Re; Planning application EP / 7 / 18 / PL

OBJECTIONS TO PLANNING APPLICATION EP/ 7/18/ PL

**LAND TO REAR OF BEECHLAND "COTTAGES"/ NORTHERN PARADE OF SHOPS
EAST PRESTON**

Elevations of new stircase to existing building

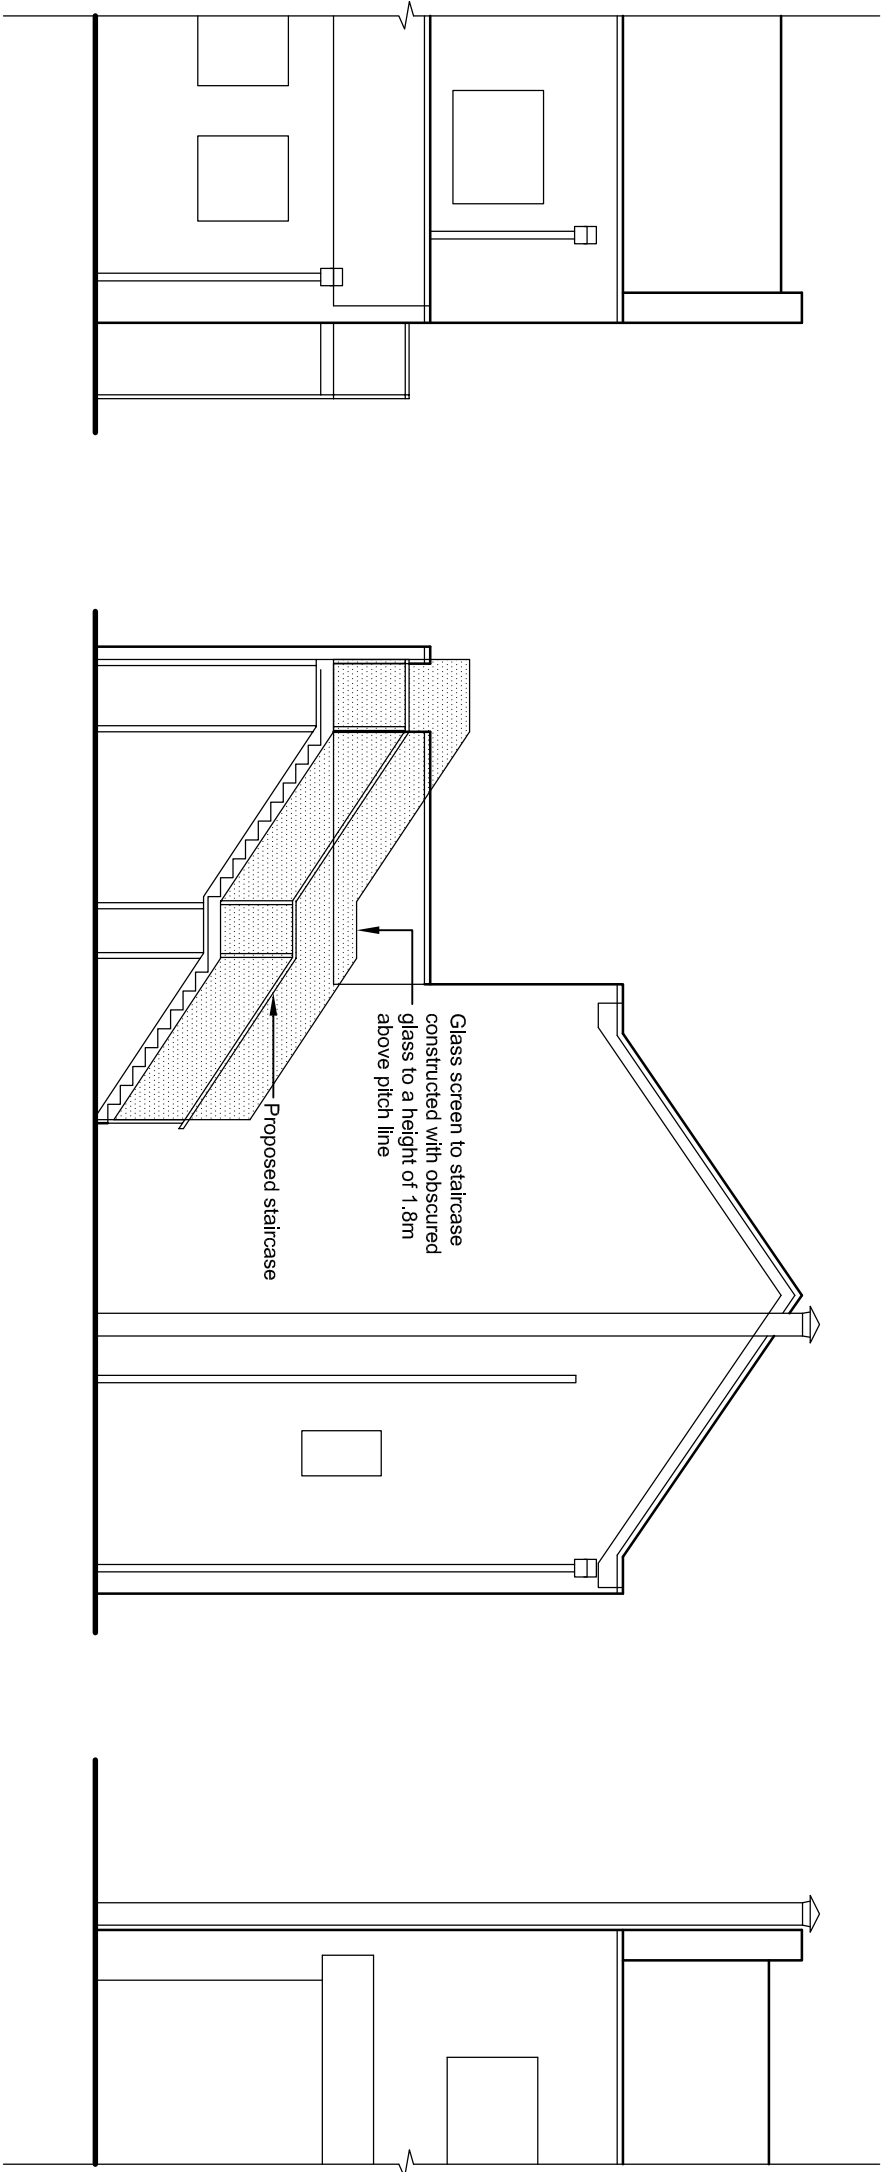
The re-positioning of the ugly metal staircase on the Northern end of the existing balcony to the rear of the flats would be unsightly and intrusive being only **3.2 metres** away, it would interfere with our privacy as it's proposed position is adjacent to our conservatory / dining area and open to anyone residing in or visiting the flats adjacent to our property.

As an escape route it would require the unlocking of the inward opening gate at the end of the alleyway which has been closed to all since the mid-eighties, this to allow permanent egress/ access to anyone, as yet no detail has been provided as to how this could be controlled. The gate should open out not in and have an efficient controlled device to prevent it being left open for access by all and sundry, panic bars are designed for internal doors and do not close gates.

Re-allocation of existing staircase.

I doubt this cast iron staircase is suitable under current regulations *'to be taken down and allocated'* At present it used as the main access route to the flats from the car park and provides the only access for the 2 flats over "One Stop" ie 139 and 143. The occupiers of these two flats have only one means of access and egress to their homes as their original main staircase leading down to the front of the parade of shops was removed to allow one-stop to expand their premises below only the upstairs access hallway now exists with a cupboard at the rear though it is still shown on drawings. Last summer outside of these 2 flats there was a fire on the rear balcony, the only means of escape for the occupants including two small children in this situation would have been to utilise the current metal staircase, fortunately they were away on holiday. The proposal now is to place this escape route on the northern end of the balcony **34m** away from them with no other means to access the ground safely effectively leading them into a hazardous situation. Washing lines are strung across the balcony inhibiting escape as the landlords have used their gardens to build on previously EP/49/10/DOC (Beechlands Cottages) Photo 1. There is an internal staircase leading between the 2 flats at the Northern end over the fish and chip shop ie no 129 and 133 but this has a locking door exiting onto the balcony and a further locking door at the bottom of the staircase opening inwards thus preventing it's use as a means of escape in an emergency. As the extractor system for the Three Oceans fish and chip shop is situated in this alleyway that would further impede egress in the case of evacuation should the staircase be re-located, no lighting has been mentioned.

In the event of a fire in the Three Oceans fish and chip shop with it's deep fat fryers situated below and adjacent to the only 2 staircases mentioned previously, neither the one remaining internal staircase *or* the repositioned metal fire escape could be used, leading to potential loss of lives.

Proposed Plans and Elevations

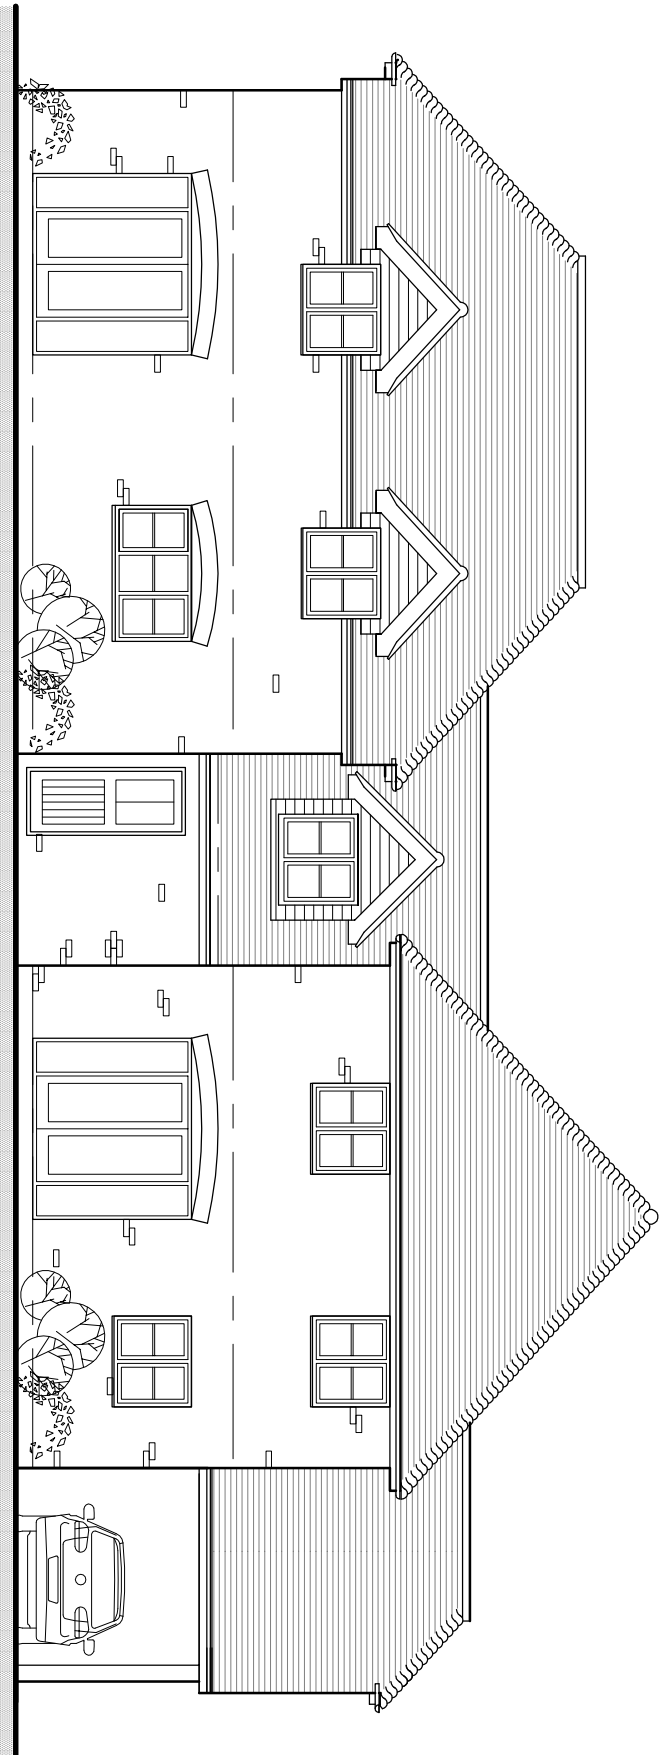
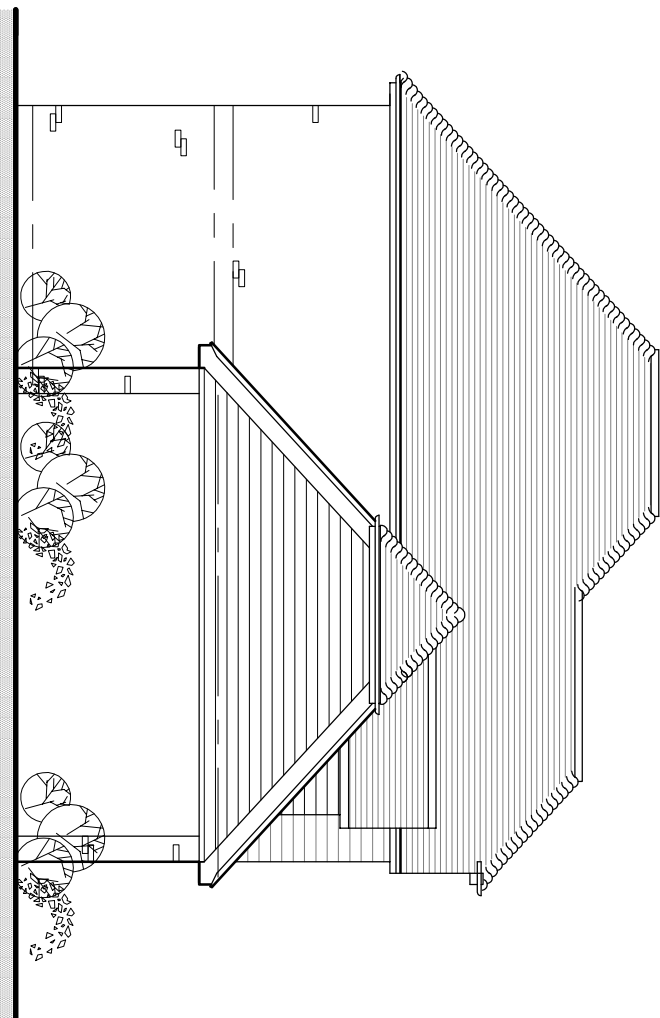
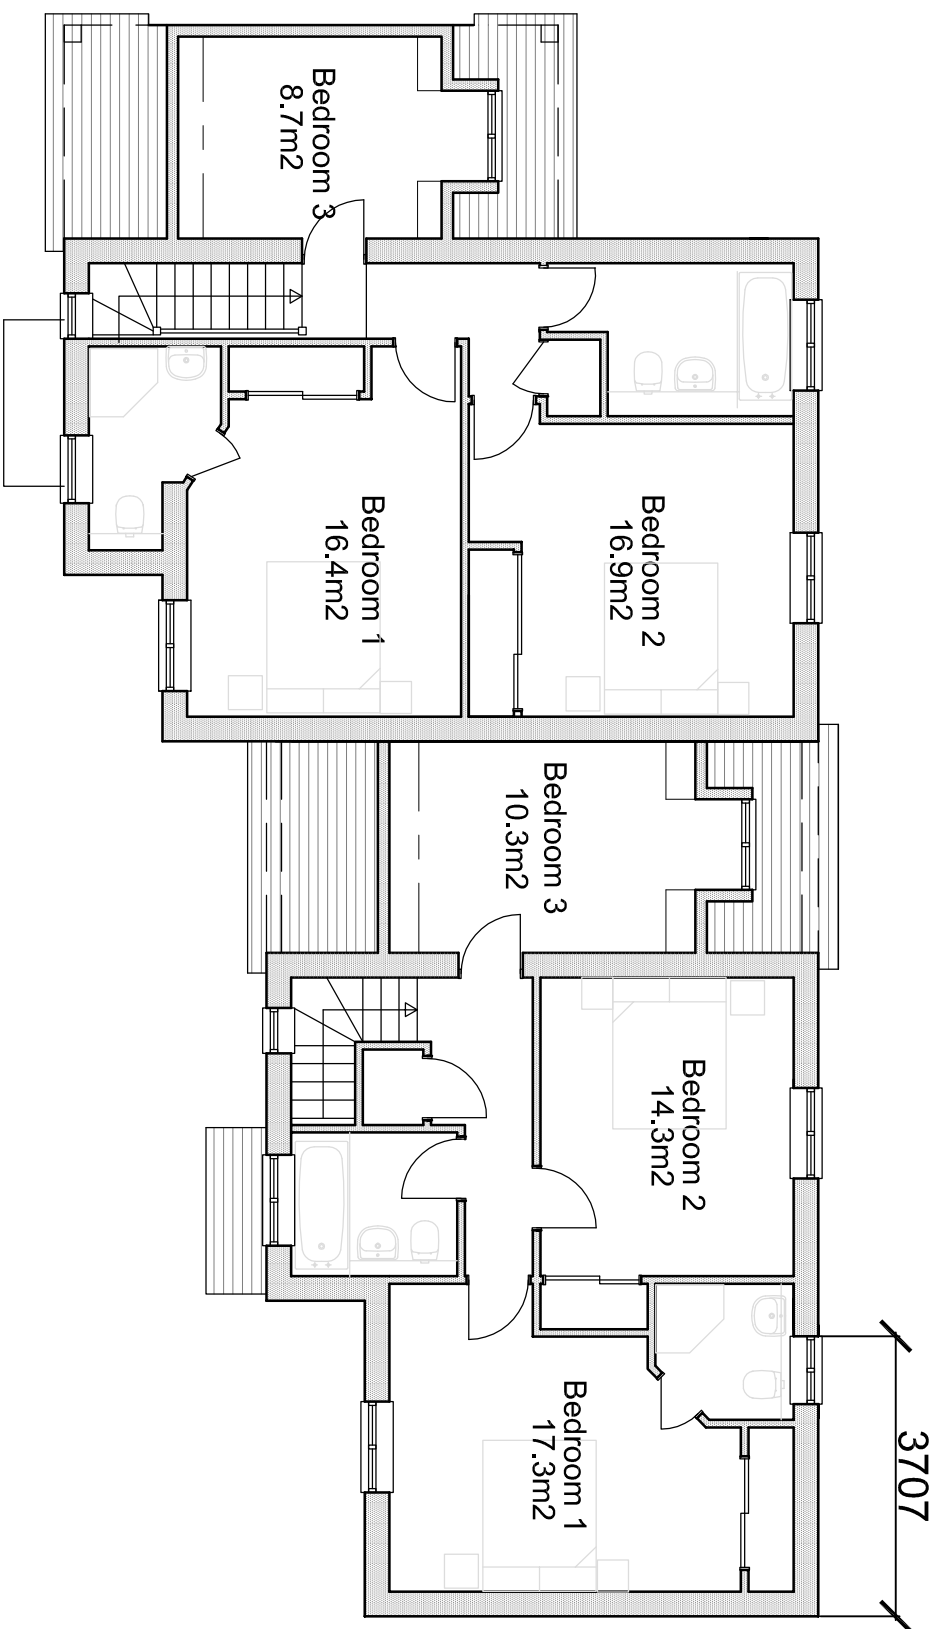
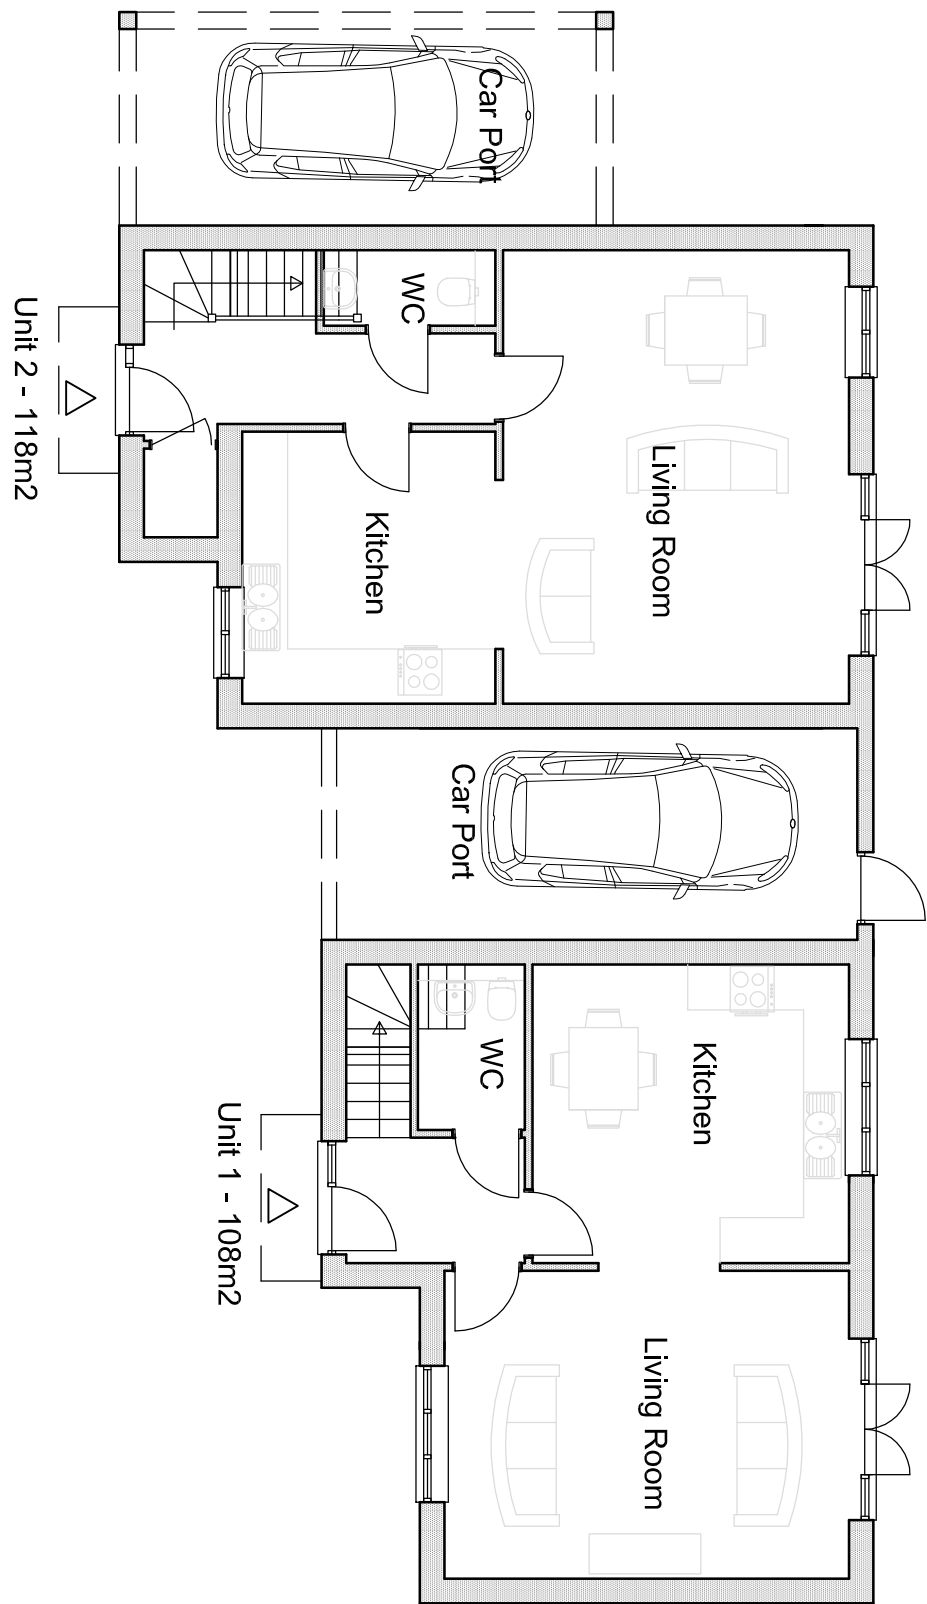
At almost 9 metres to the ridgeline the design and height of the proposed dwellings will cast a shadow on our garden and severely restrict any sun particularly from sunrise to midday during the winter months when it is at its lowest.

The design and height will have an overbearing impact on us by invading our privacy and considerably reducing the enjoyment of our property.

The rear of the proposed building line is **14.4 metres** from our building line.

Our property has been omitted from all of the plans.

The occupants of these proposed dwellings will have a clear view into our home if they are built, their views would be further enhanced by the reduction in the height of our existing 2.7 metre high boundary wall forming the back of the 'to be' demolished garages. The substantial wall on removal to be replaced by an 1.80m high wooden fence on the plans.
